Morris Goding
Access Consulting

18 February 2021

RE: Sirius Redevelopment - Response to Department of Planning, Industry and Environment Accessibility Statement Final

1 DDA TYPE 3F - 14.15.02 - PRE

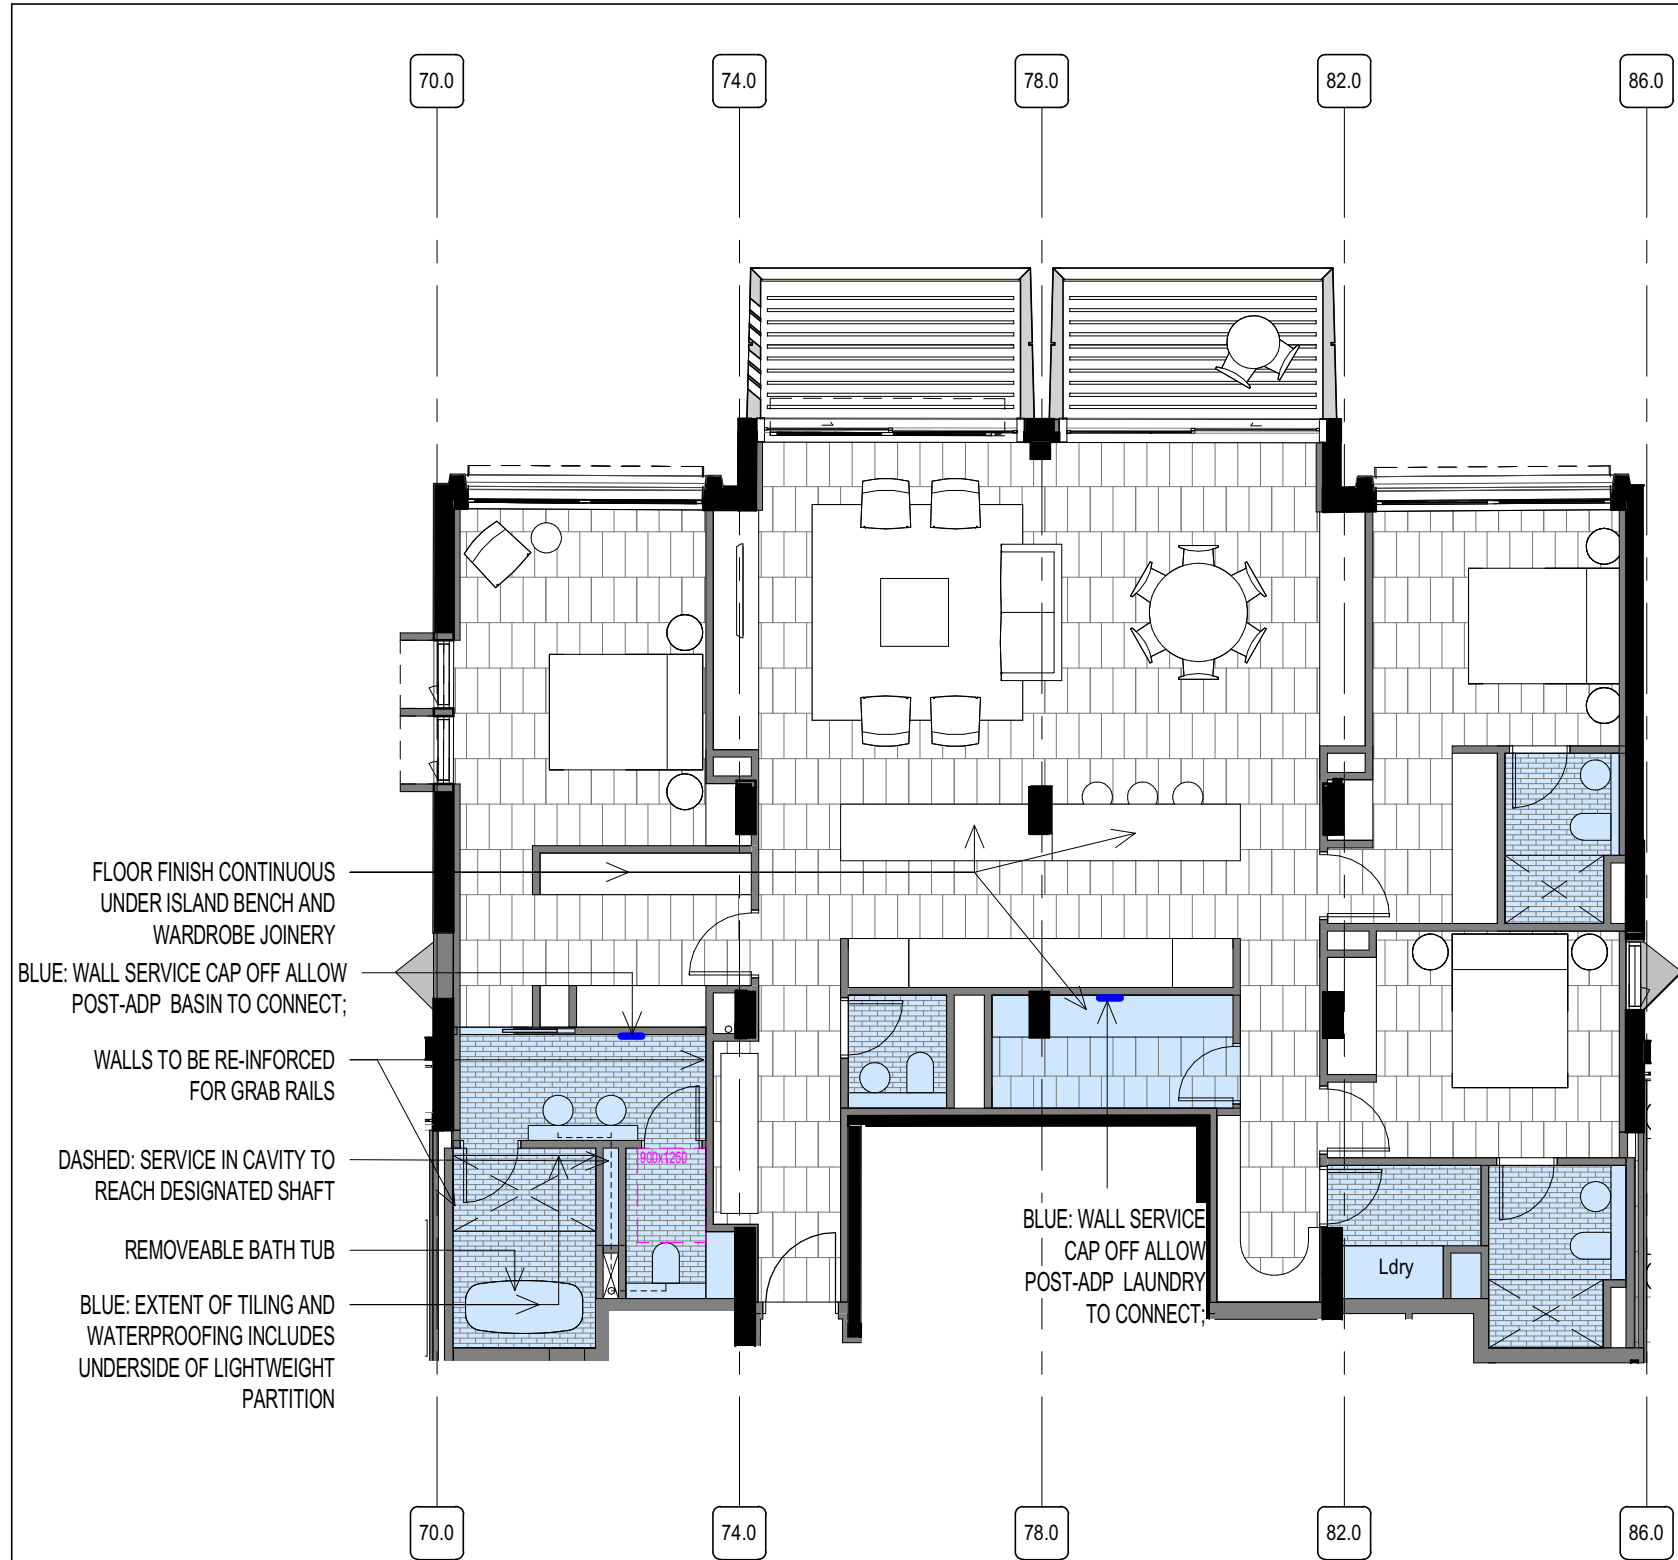
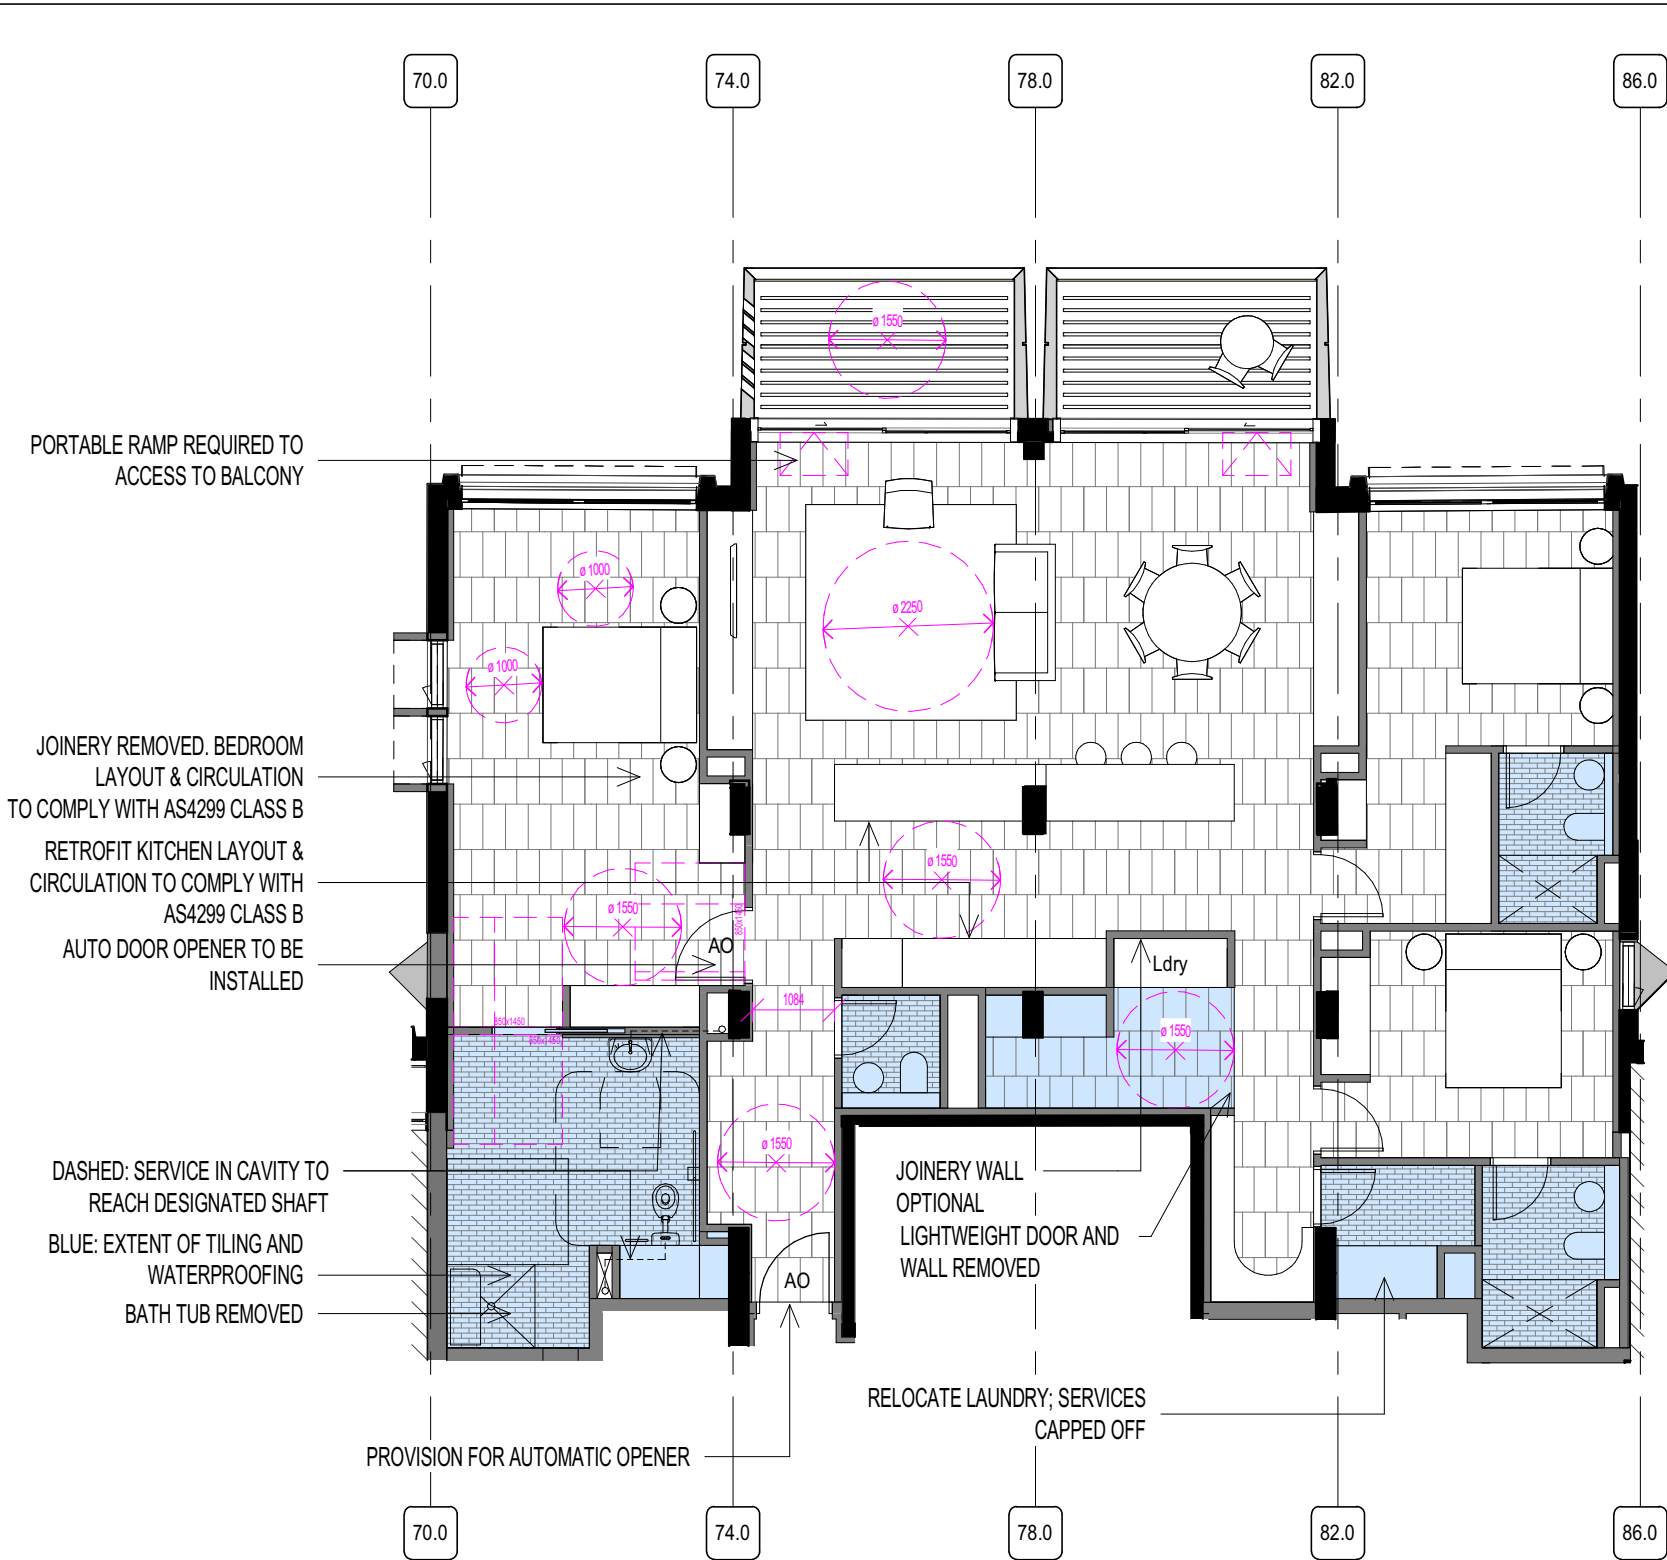
The design of adaptable unit types 3F and 3H (attached in Appendix A below) were assessed within MGAC’s Access Impact Statement and feedback from the City of Sydney Council is

- The accessible bathrooms to adaptable unit types 3F and 3H will show toilet pans and shower recess falls retaining their position between pre and post adaptation and capped off services for the where the washbasin will be relocated at post adaptation are included from the outset. The walls within the bathrooms are annotated lightweight partitions for easy removal at post adaptation. Waterproofing includes the underside of these lightweight partitions. Wall strengthening will be provided from the outset in the toilet pan and shower recess walls to allow for easy future installation of grabrails as per AS4299. As per the provisions of AS4299, a removeable bathtub is permissible.

- The kitchen island benches in adaptable unit types 3F and 3H may be relocated at post adaptation as stipulated in AS4299. The post adaptation drawings show a potential configuration that will comply with AS4299 Clause 4.5. The drawings show continuous flooring underneath the island kitchen bench and the sink waste will be located at the back of the bench such that upon adaptation, the existing joinery can be shifted back to achieve the required circulation spaces. It is MGAC's opinion that the provision of continuous flooring underneath the island bench and suitable location of the sink waste will ensure that adaptation will minimise inconvenience and cost.

- Within the bedroom of adaptable unit type 3F it is proposed to the remove some of the wardrobe joinery to provide the circulation space required around the queen bed in the adaptable bedroom. While there is a reduction in wardrobe space in the post adaption scheme, there is still ample wardrobe space allocated with significant circulation space as is desirable in AS4299 Clause 4.6. With the greater circulation provided by the removal of the extra wardrobe space, there is some flexibility for the owner to provide additional wardrobe space if desired, while maintaining circulation space around the queen bed. It is MGAC's opinion that the current scheme meets the intent of AS4299 with regards to the bedrooms.

- The comments relations to the changes required in the laundry for both adaptable unit types 3F and 3H are noted. Drawings show capped off services in the future location of the laundry provided from the outset and initial joinery can be easily removed as continuous tiling has been provided in this location.

noted. The design has been adjusted to reduce the cost and effort required to during post adaptation stage.
